REQUEST

Proposed Zoning: UR-2(CD) (urban residential, conditional)

Approximately 2.09 acres located on the northeast side of The Plaza, south of Bridgeport Drive, and west of Barrington Drive.

The petition proposes to allow an infill residential development with 26 single family attached (townhome) units on vacant land north of the intersection of The Plaza and Milton Road.

TECHNICAL  
DATA SHEET

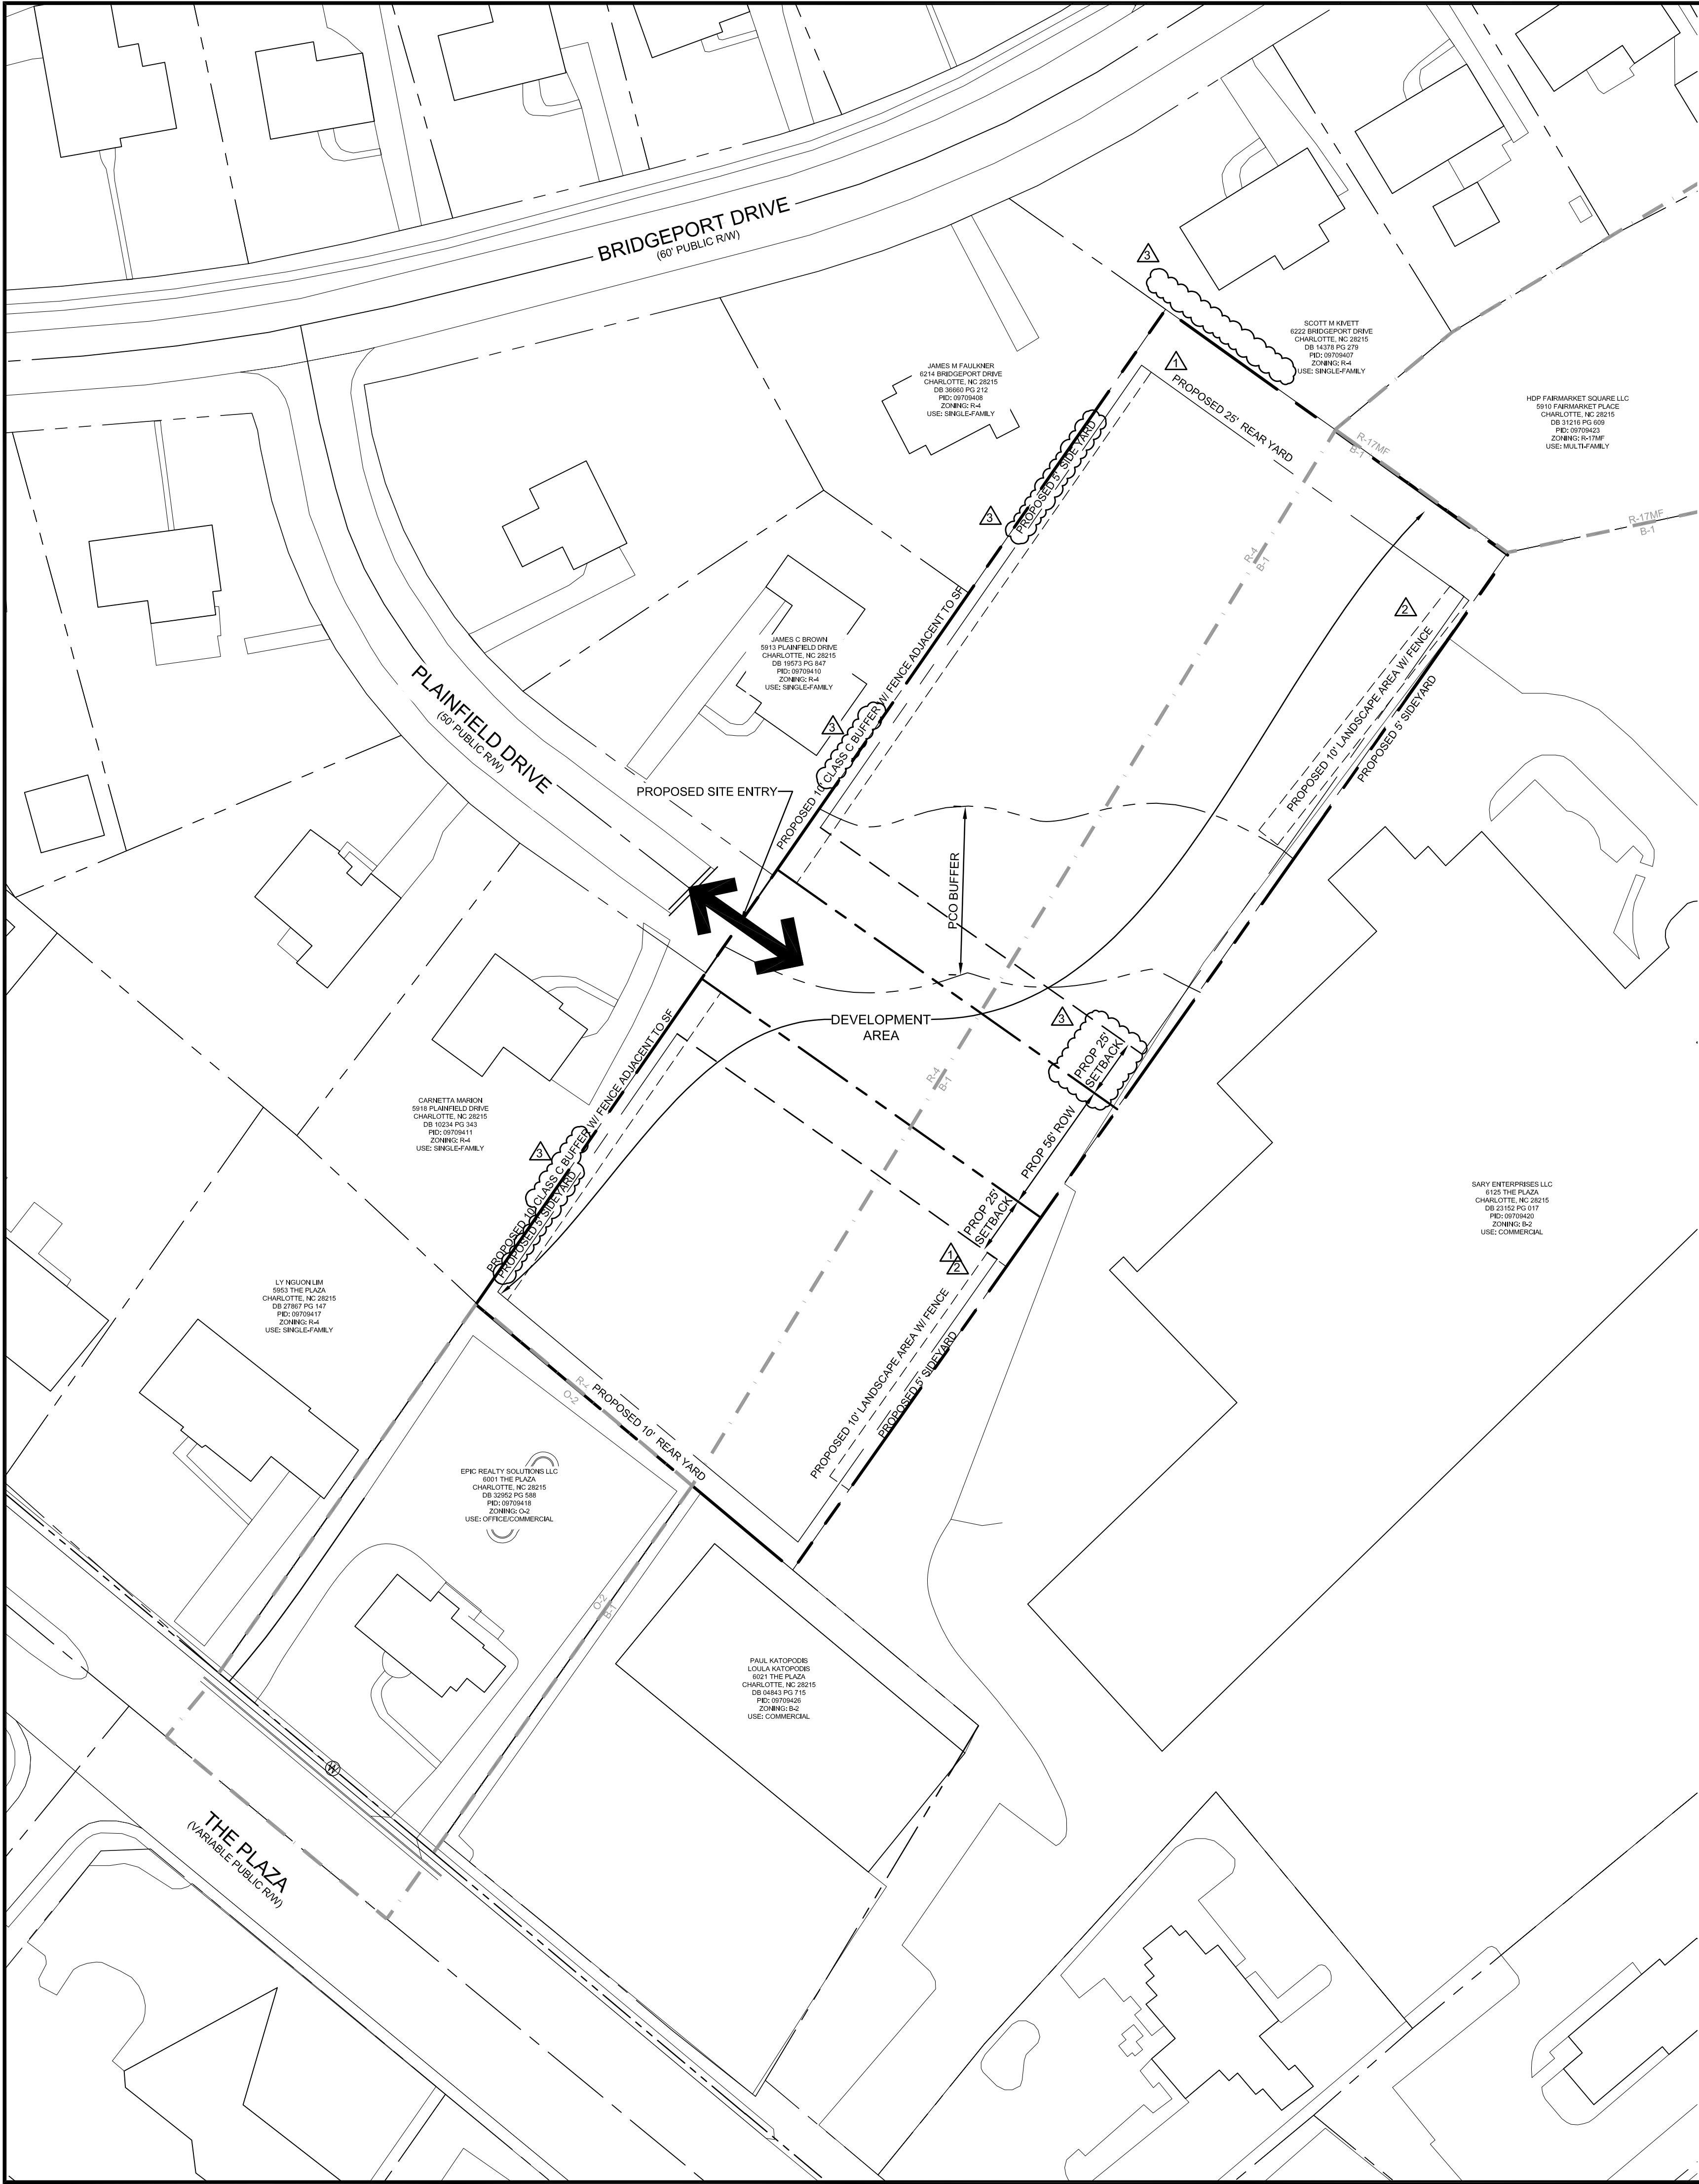
2. Ensure that tree save meets proper standards. Protected tree save should be roughly 30 feet wide. Any tree save not protected to meet the minimum requirements will need to be replanted at 150%

REZONING  
SITE PLAN

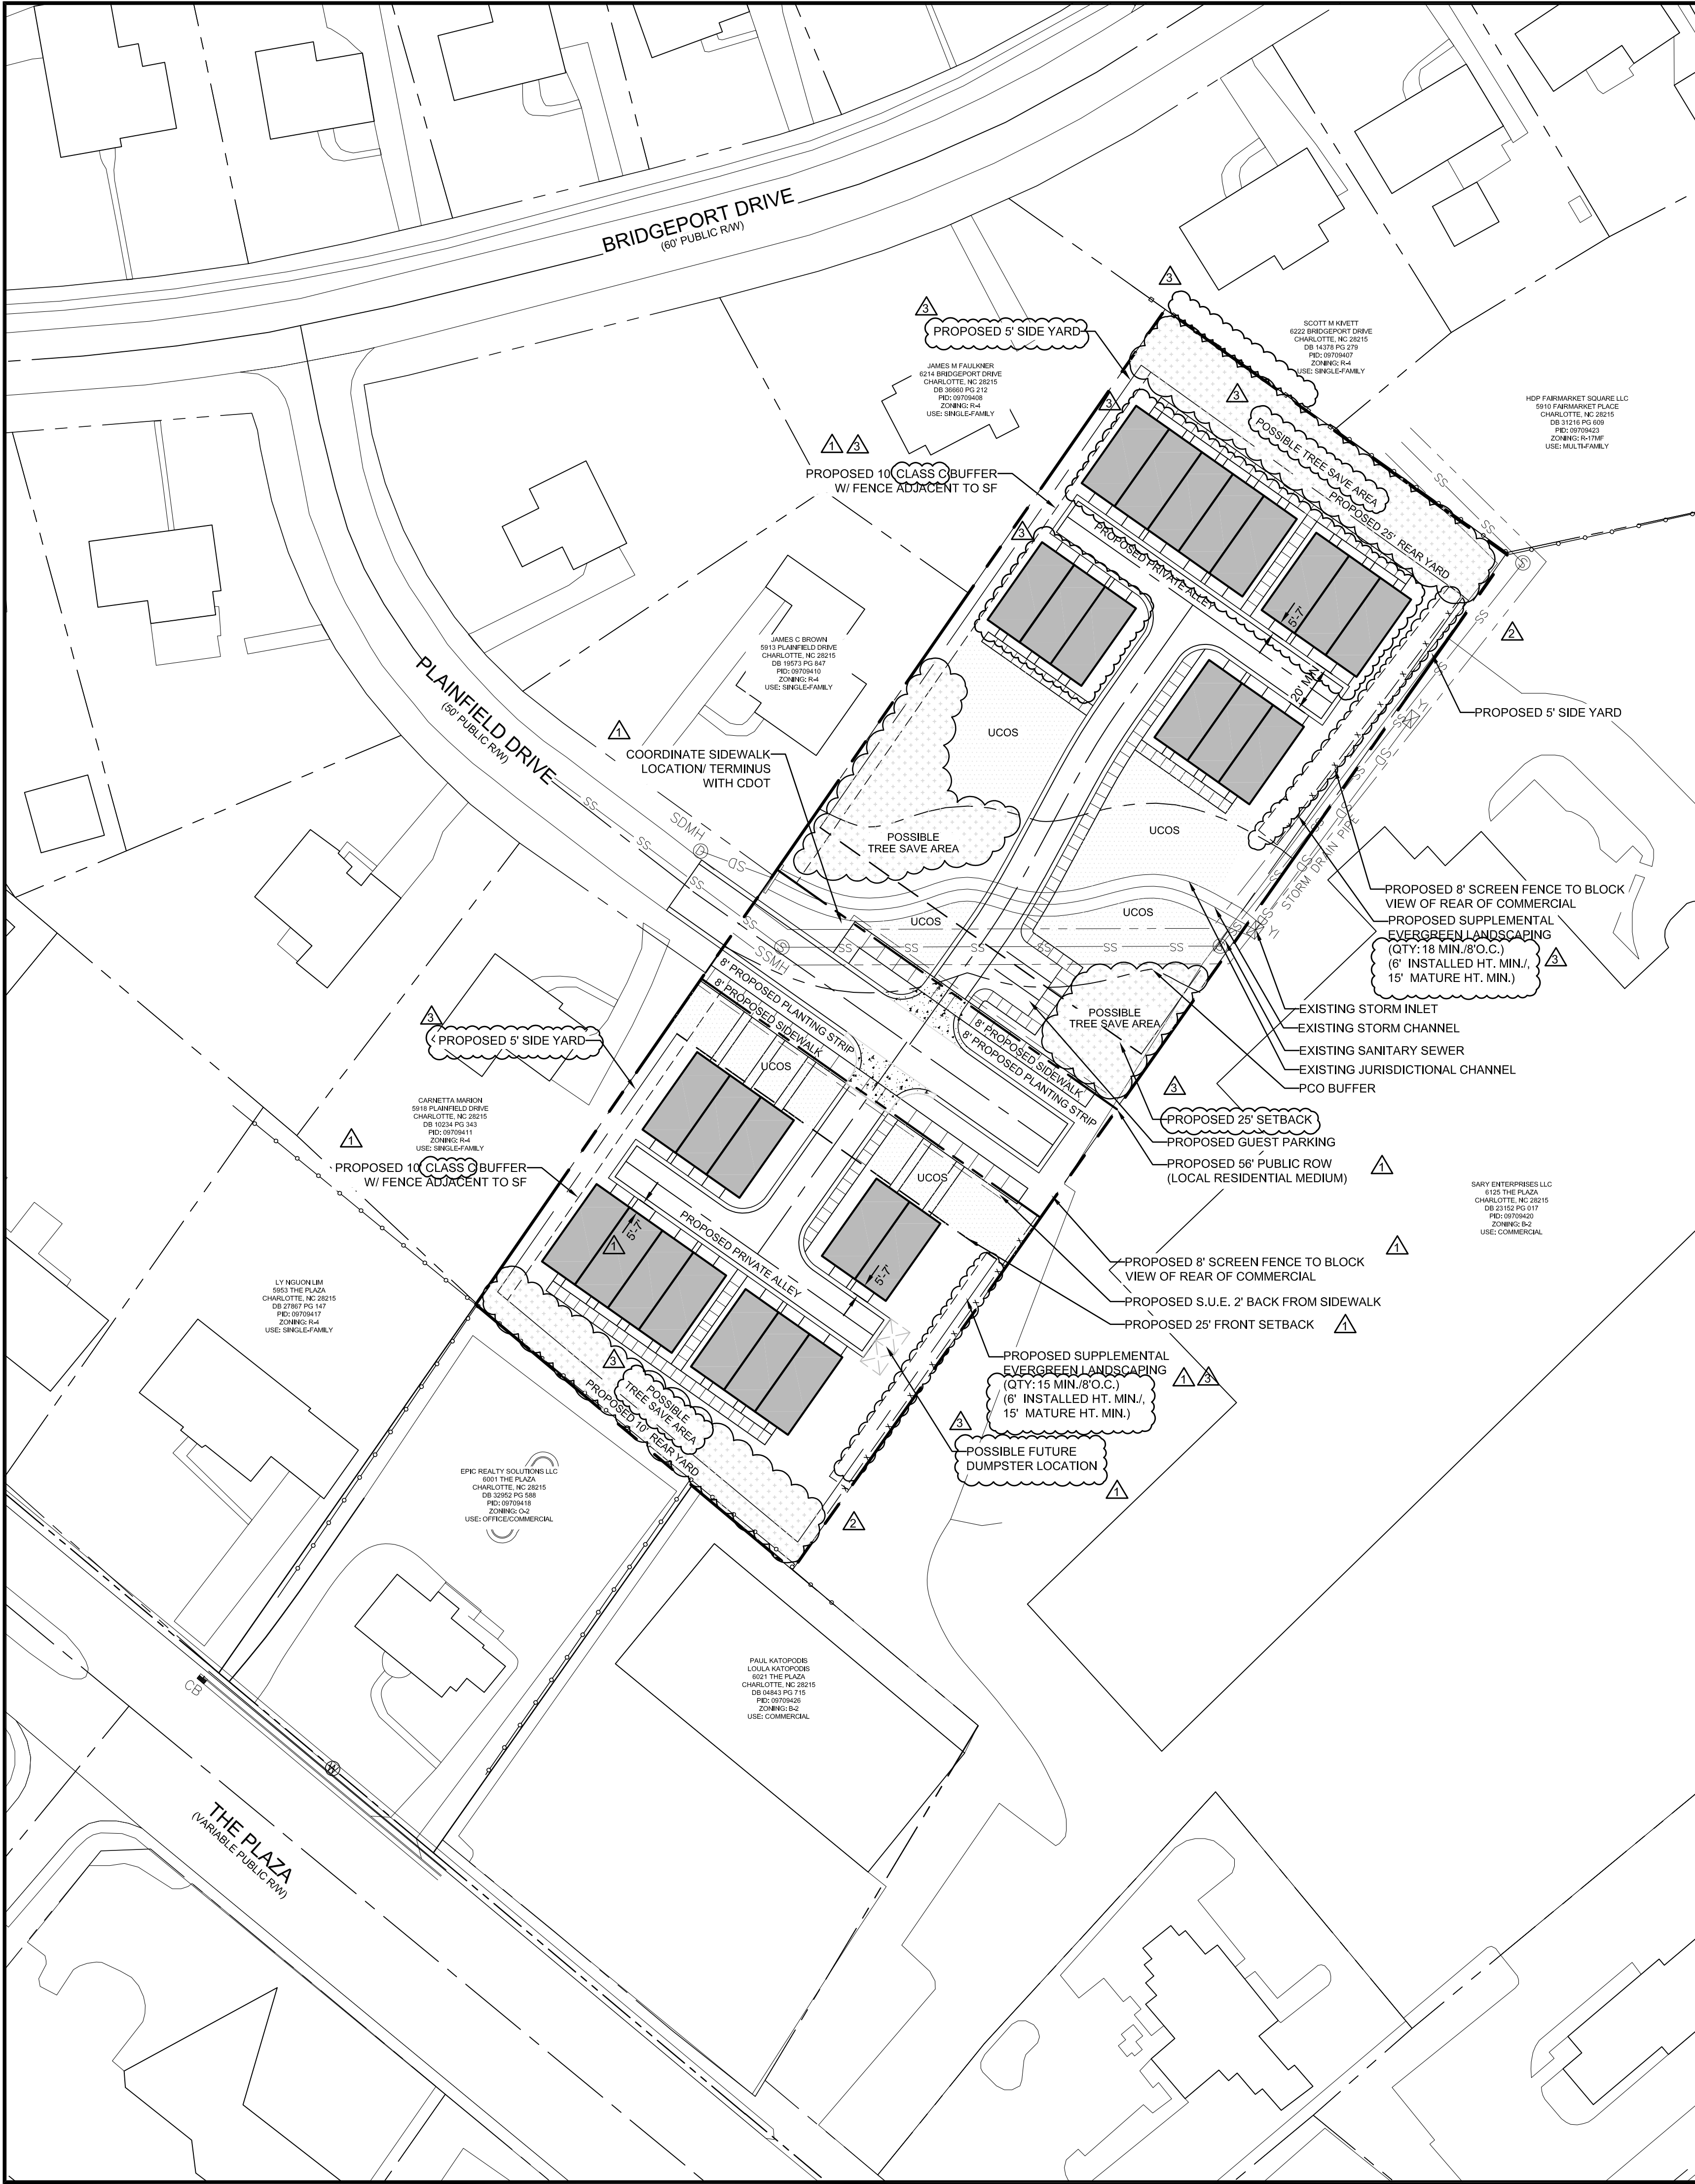
- ~~1. The proposed dwelling units exceeds 12 per acre. Per Chapter 20 Subdivision ordinance, site plan and conditional note(s) revisions are needed to commit to construct an 8-foot planting strip, and 8-foot sidewalk along all public roads. The wider sidewalk also meets the Charlotte WALKS Policy. Reference (CLDSM standard detail U-02) for residential medium street typical. Clarifying Comment 12-21-22: Petitioner should add conditional note stating commitment of 8' planting strip and 8' sidewalk along both sides of all public roads. Reference (CLDSM standard detail U-02) for residential medium street typical section. Potential environmental conflicts to be coordinated during permitting if full section cannot be achieved.~~
